Re Planning Ref R/53/13

Further to the permitting of this planning application on 12th April 2013, which was subject to compliance with certain conditions, I am writing to advise you of additional action being taken in order to comply with condition 4.

Following discussions it was agreed to revise the Protection scheme to the Scots Pine trees on the western elevation.

WEST ELEVATION –STREET
(As Proposed)

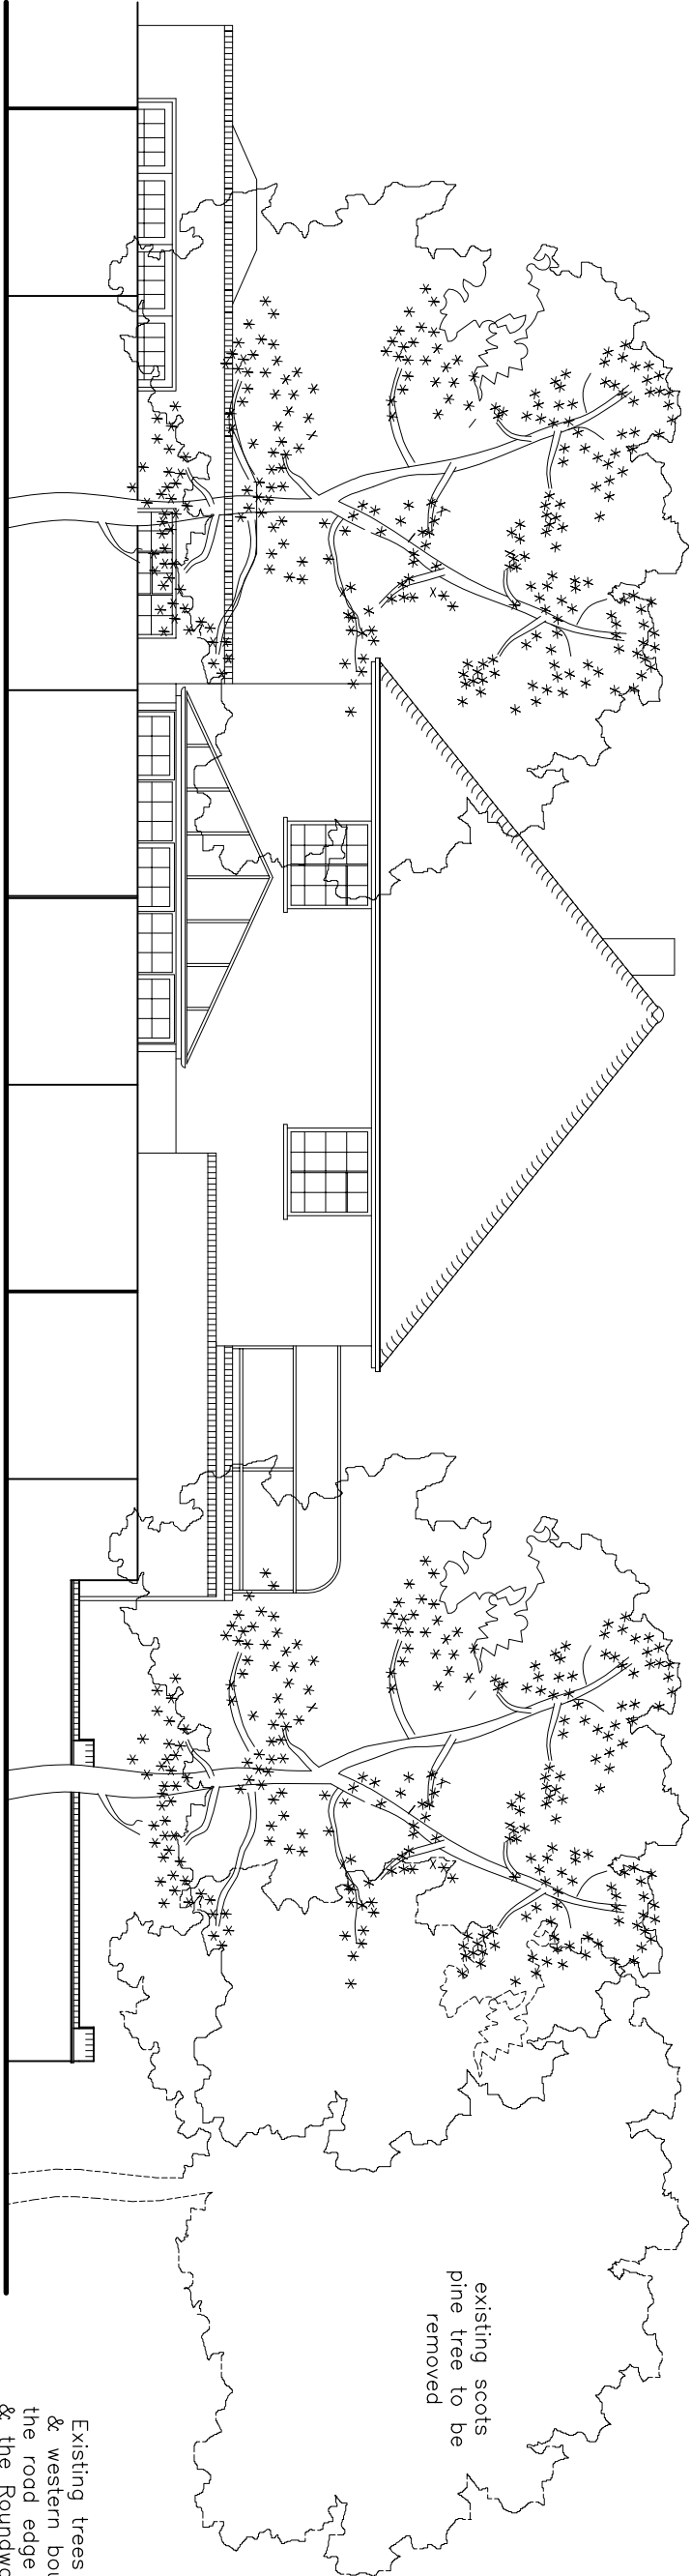
Instead of the 1200mm deep concrete bases and beam arrangement, which was considered by Mr. Brewster to be potentially injurious to the wellbeing of the trees, it was decided to reduce the proposed wall thickness which would allow us to construct a more shallow foundation.

We will now be excavating a 300mm wide strip footing 350mm maximum below the existing ground level : Place concrete 200mm thick and build a half brick wall 110mm wide to match the existing wall on the western elevation.
